Response to Planning Application

Application ref: BN/65/22/PL

Description: Sever land and erection of 1 No bungalow with new vehicular access (resubmission of BN/14/22/PL). This application is a Departure from the Development Plan and is in CIL Zone 3 and is CIL Liable as new dwelling.

Location: Land at rear of Cedar End Eastergate Lane Eastergate PO20 3SJ

Proposed Site Plan
1:200

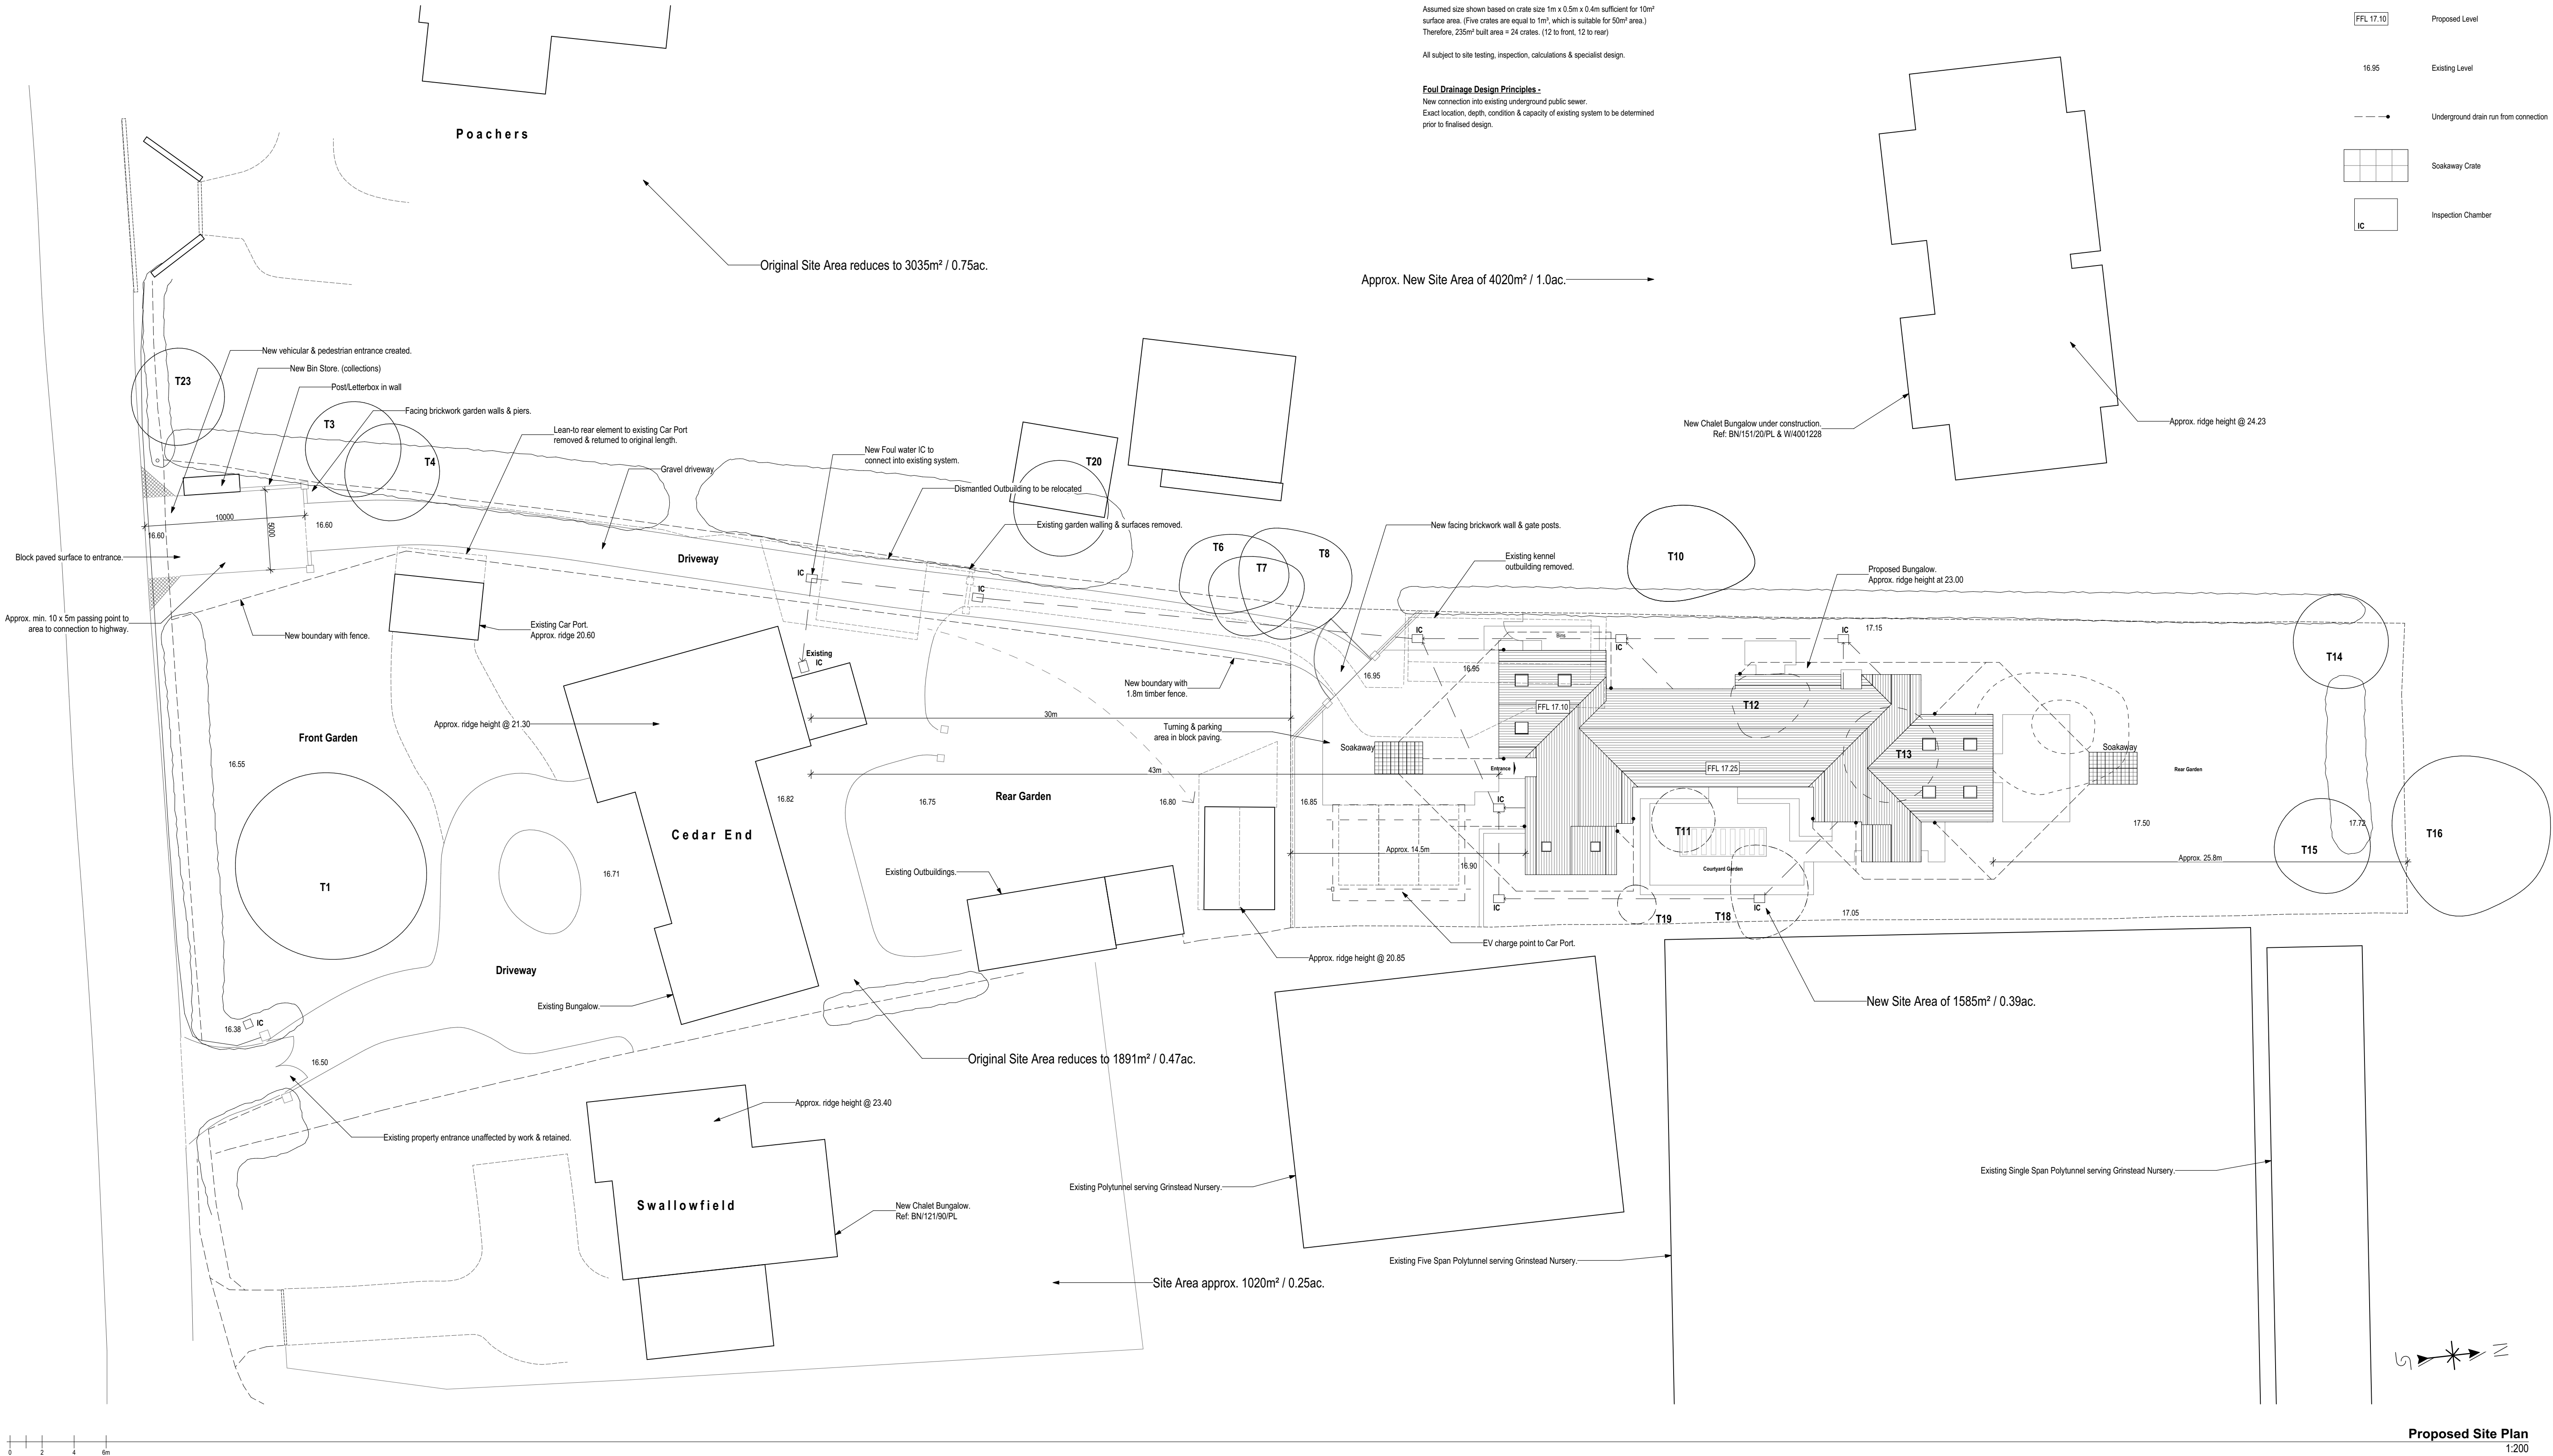
The NPPF para 124/127 relate to good design principles which equally apply to small infill and replacement development. The indicative site layout has made reference to indicative planting alongside tree retention. These details would require expanding in the form of a detailed planting plan and specification detailing species choice, actual plant quantities, planting densities and size at time of planting. Detail should also be provided regarding existing trees and boundary planting.

The scheme has not provided landscape detail which would be a requirement of any decision in order to show greening and potential screening to adjacent properties and also in accordance with the ALP policy ENV DM5 details of biodiversity net gain would be required or to be conditioned. The proposed landscape scheme will be required to be submitted in plan form detailing species choice, quantities, planting densities and size at time of planting.
